WEST SUSSEX COUNTY COUNCIL CONSULTATION

TO:	Arun District Council FAO: Anita Gardner
FROM:	WSCC - Highways Authority
DATE:	20 August 2020
LOCATION:	55 Milton Avenue Littlehampton BN16 2PL
SUBJECT:	R/138/20/PL Demolition of garage & construction of 1 No. 2-storey chalet dwelling (resubmission following R/182/18/PL).
DATE OF SITE VISIT:	n/a
RECOMMENDATION:	Advice
S106 CONTRIBUTION TOTAL:	n/a

ground floor plan

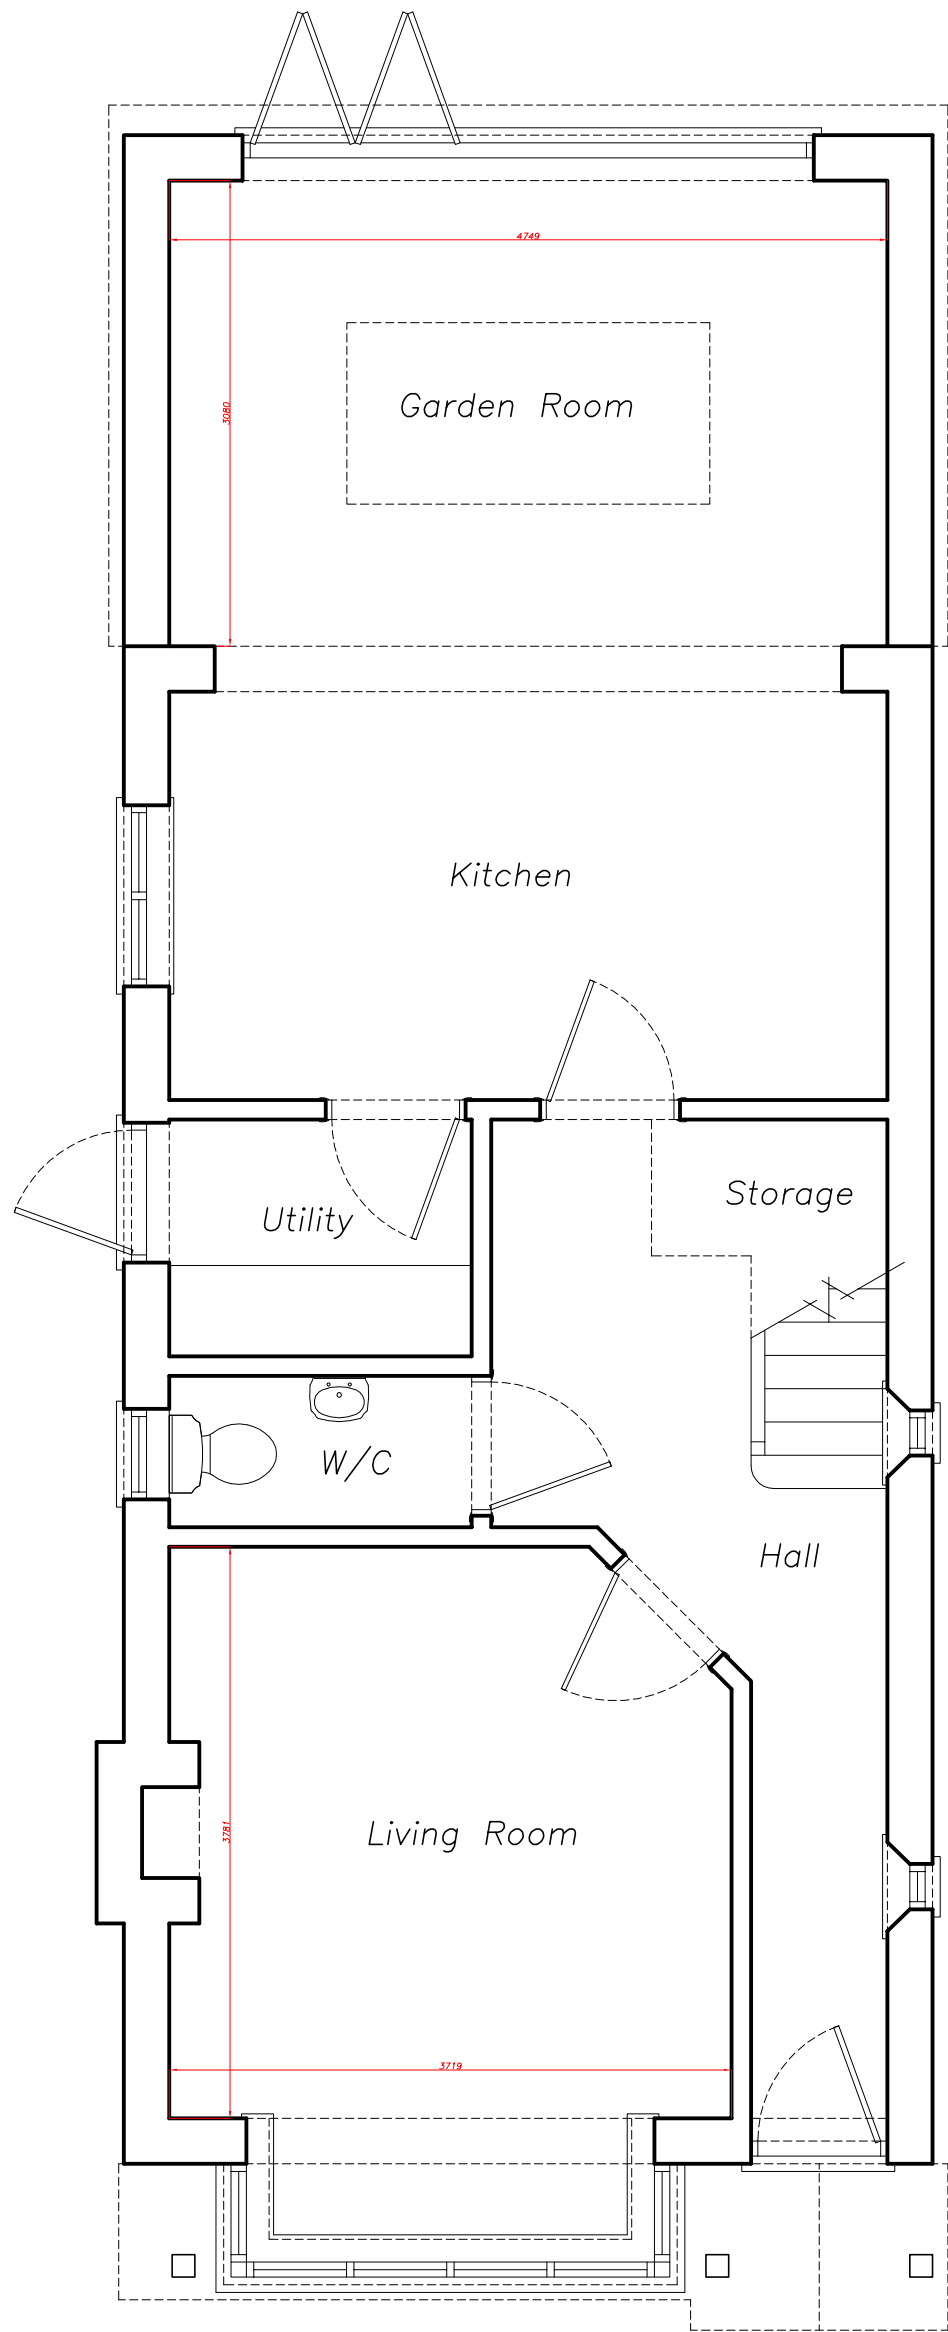
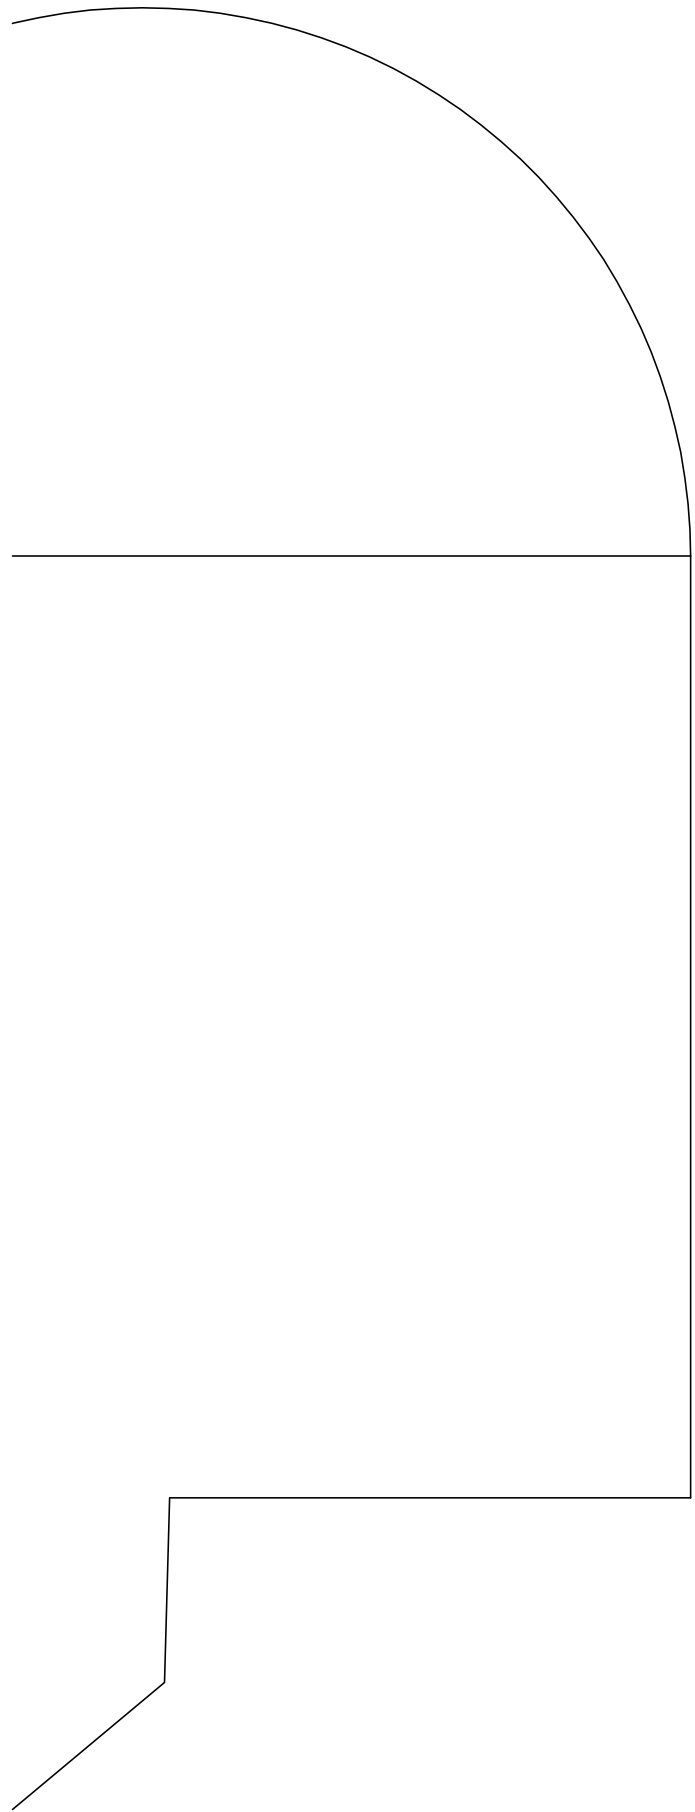
The proposed plans indicate that there is sufficient space on site for one vehicle to park on the proposed site frontage. The WSCC Parking Demand Calculator expects that a minimum of two parking spaces would be required for a dwelling of this size and location. No details of parking provision for the existing dwelling have been provided. Any overspill parking could be accommodated on-street, although the LPA may wish to consider the potential impacts of on-street parking as a result of this development from an amenity point of view. A turn on site would be preferable although there is clearly insufficient space on site to achieve this. An inspection of local mapping indicates that a number of neighbouring properties have similar arrangements and these have been operating without evidence of highway safety concern.

No part of the development shall be first occupied until the car parking has been constructed in accordance with the approved site plan. These spaces shall thereafter be retained at all times for their designated purpose.
